Re: BusConnects Clongriffin to City Centre Core Bus Corridor Scheme
County Dublin

RE: BusConnects Clongriffin to City Centre Core Bus Corridor Scheme County Dublin
An Bord Pleanála Ref. No. 313182-22

RE: Bus Connects - Clongriffin to City Centre Clarehall Shopping Centre

CLONGRIFFIN TO CITY CENTRE CORE BUS CORRIDOR SCHEME  
JUNCTION SYSTEMS DESIGN  
CLAREHALL

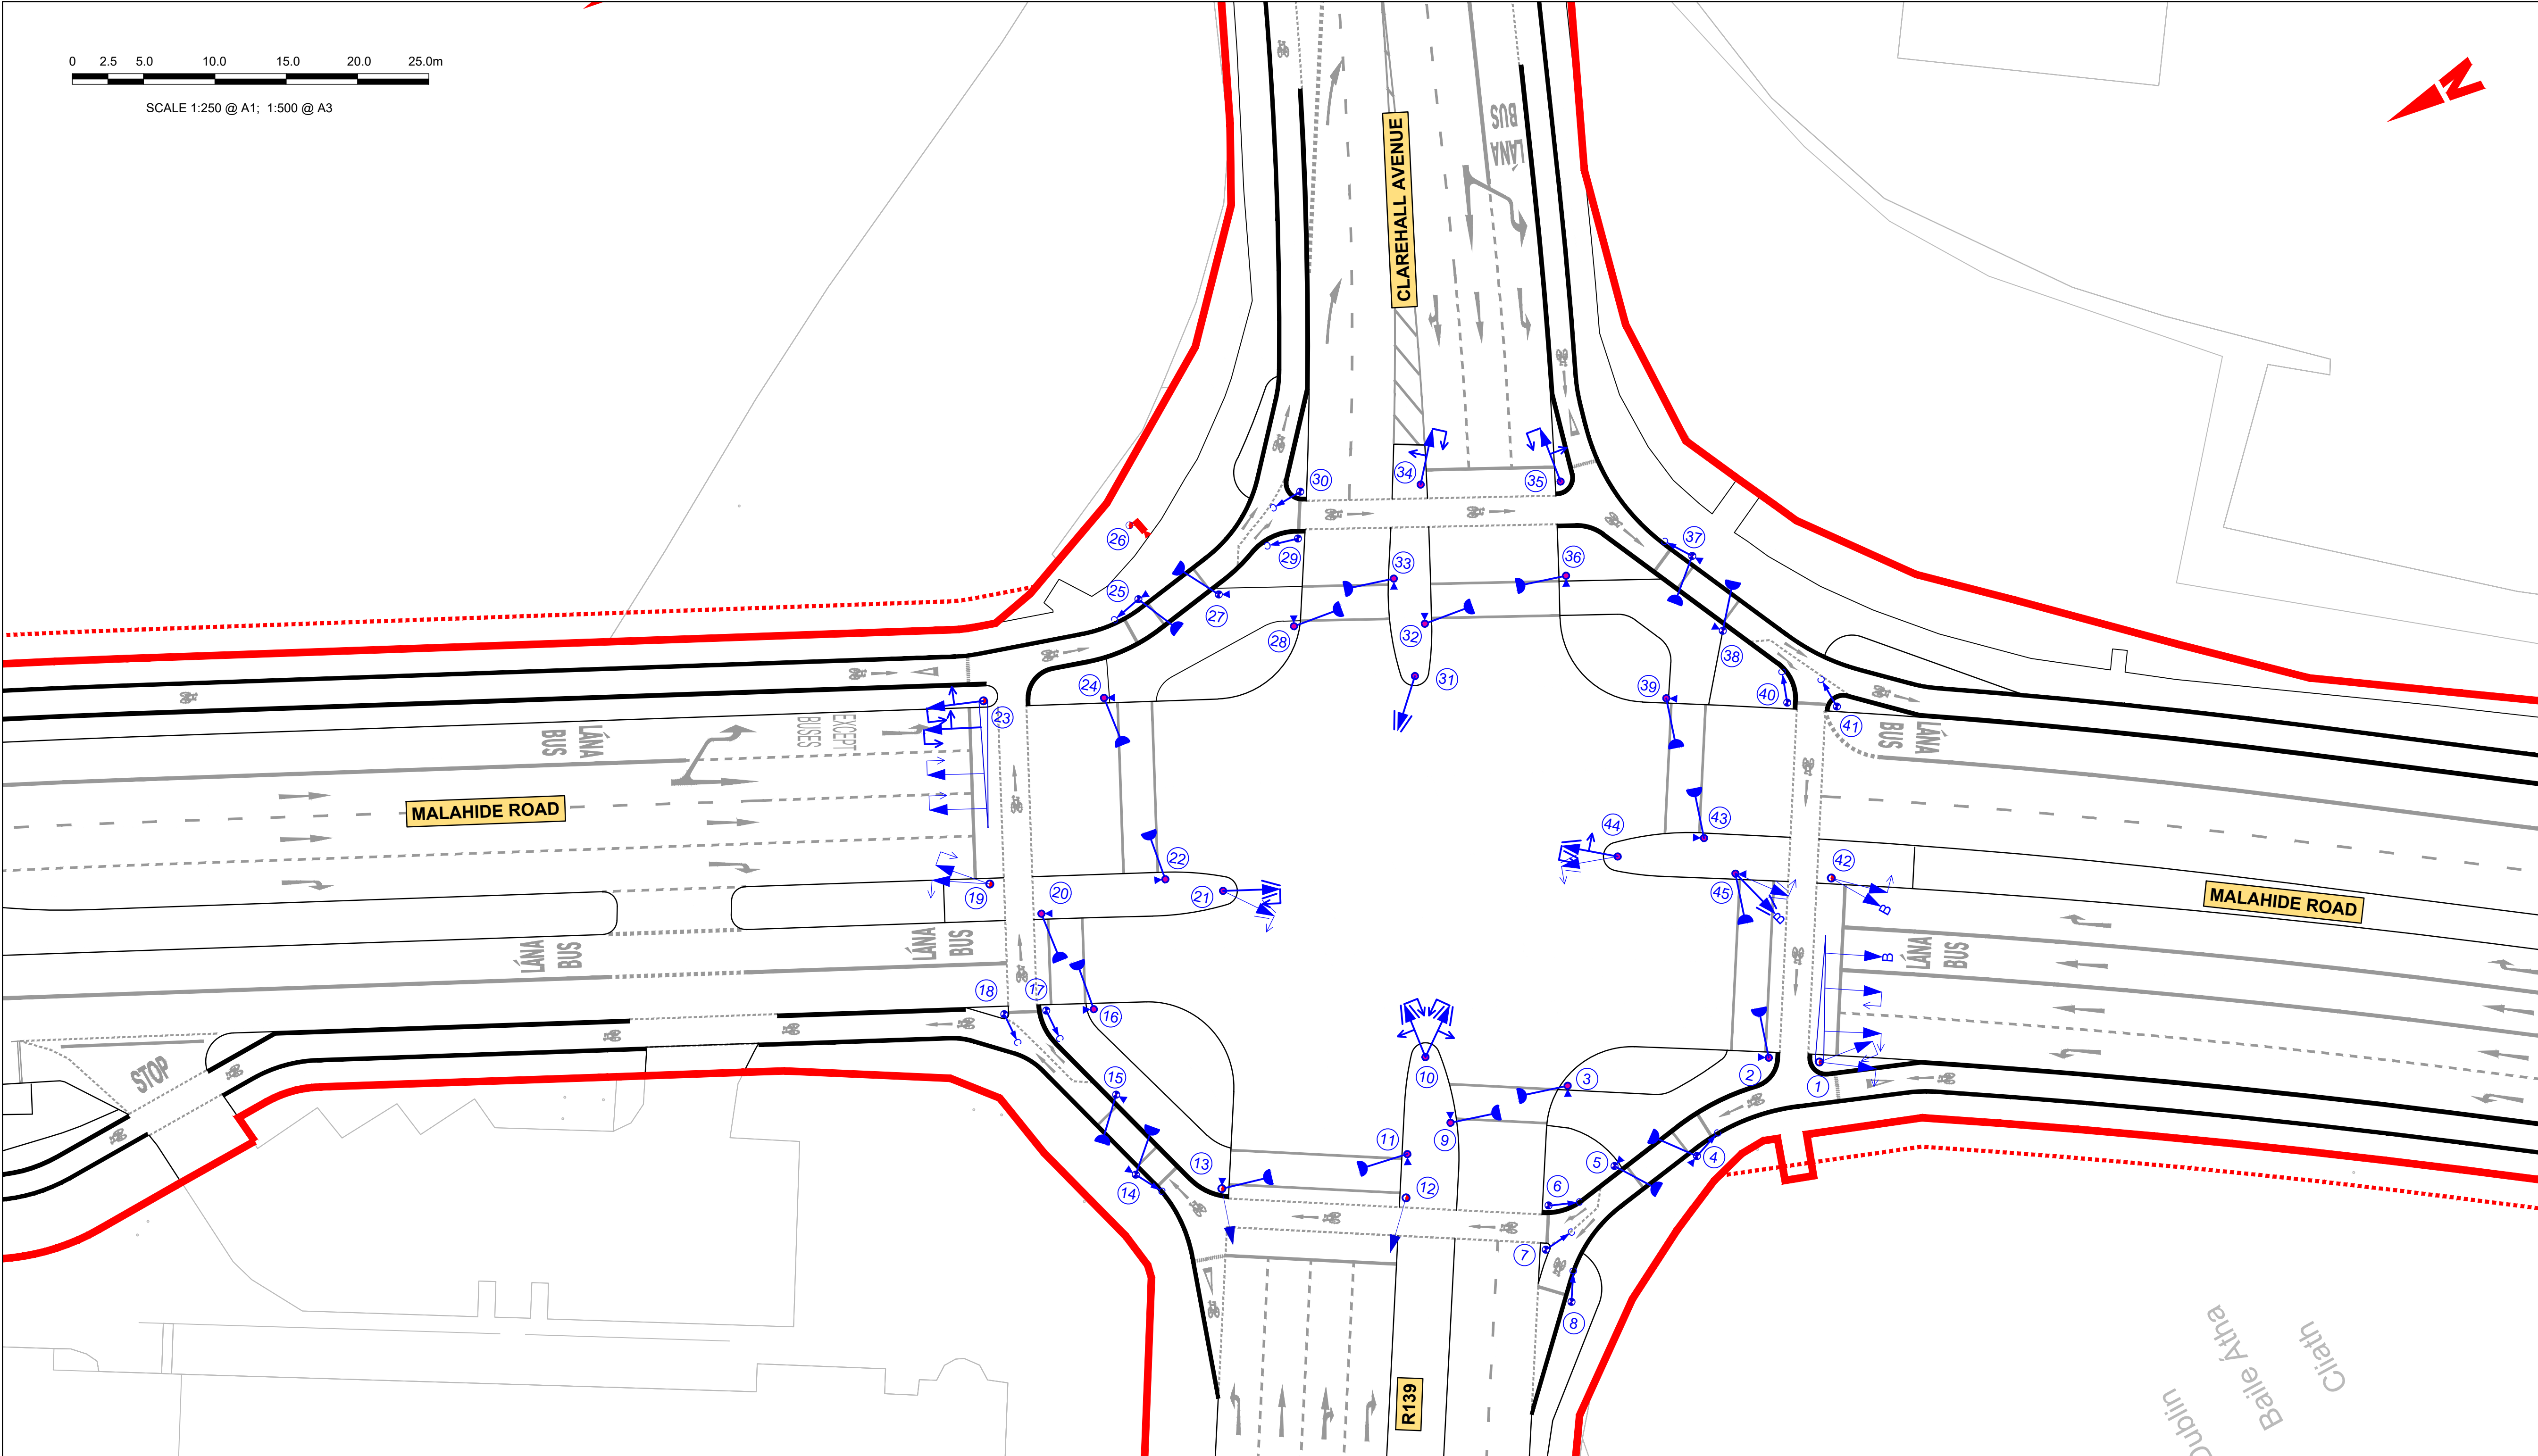
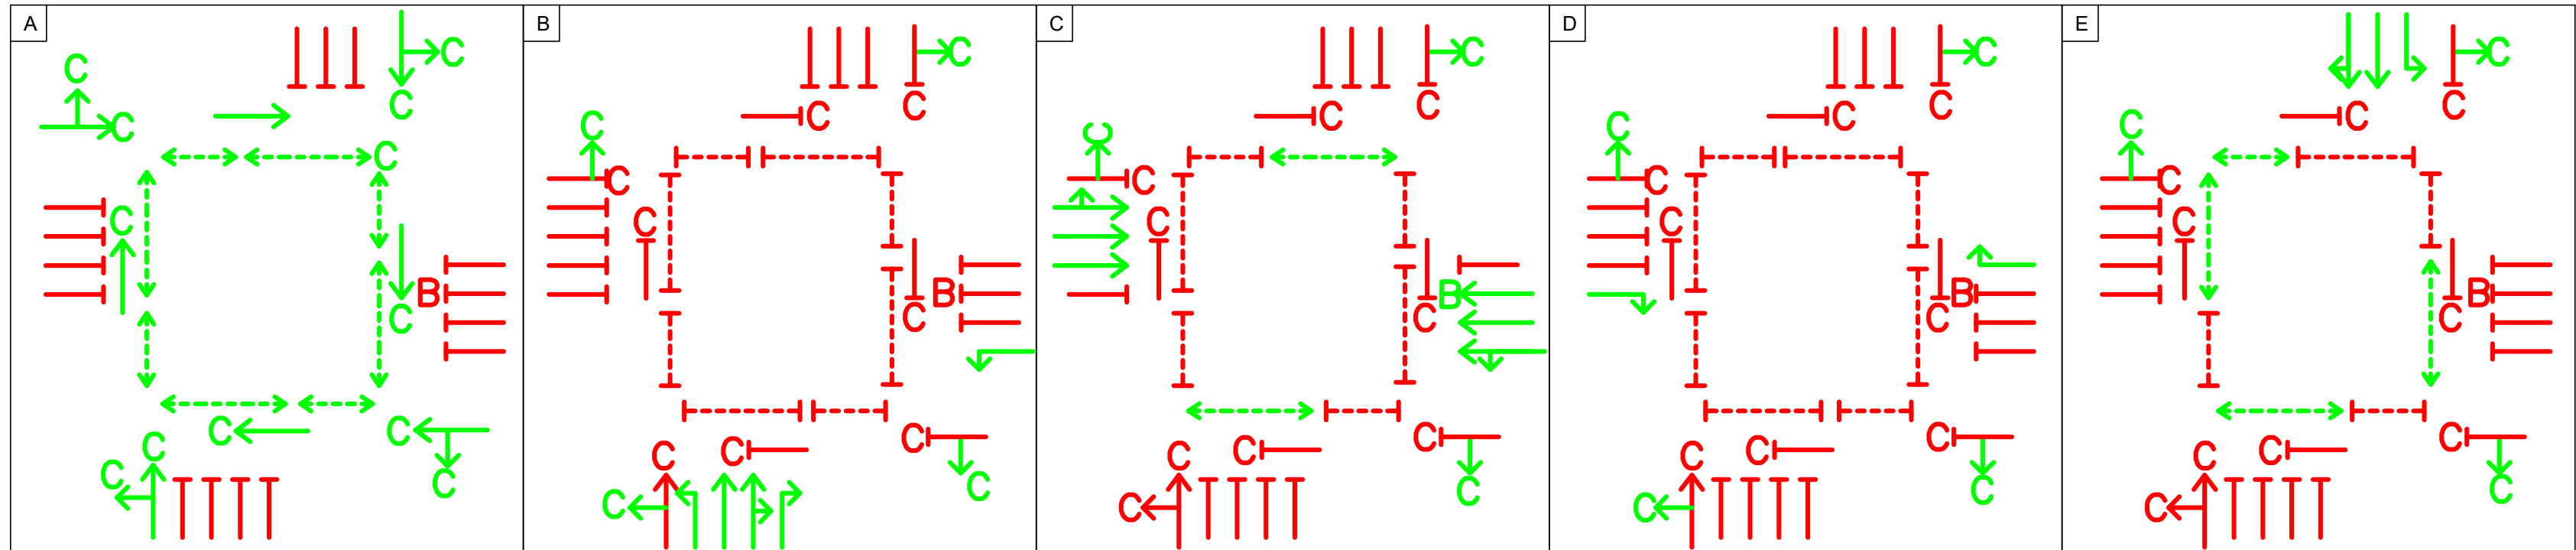
The Bus Connects team is asked to provide a swept path analysis for the maximum sized HGV permissible from all approaches to/from the development using all lanes available. Of particular concern is HGVs approaching from the west and turning into the development. The Bus Connects team are asked to demonstrate that the swept path of an approaching HGV can turn from Malahide Road into Clarehall Shopping Centre while maintaining its lane and note the potential oversailing of the kerbs provided for cyclists' protection.

The second box shows inbound cyclists stopped, left turning cyclists, left turning vehicles and in bound cars/busses going. The safety of this should be assessed in conjunction with the swept path analysis requested above.

It is Pinnacle's suggestion that when a truck is turning left that all cyclists should be held. The reason for this is due to a potential lack of visibility of a cyclist and the swept path of the HGV even when in the segregated cycle lane.

At the access to the Clarehall Shopping Centre, the modelling provided by the Bus Connects team shows the junction with a PRC of 135.3% (AM) and 96.3%(PM). This is contrary to what is experienced on site as reported by centre management particularly during retail peak periods i.e., weekends.

The Traffic and Transport Assessment does not state what calibration was used to determine the accuracy of their model. The following information, as a minimum, is lacking:

Anecdotally, and based on feedback from centre management, there is significant queuing on all arms of the junction during the retail peak periods. Note, that the retail peak may not coincide with the network peak. This should be assessed as part of the next iteration of the junction modelling.
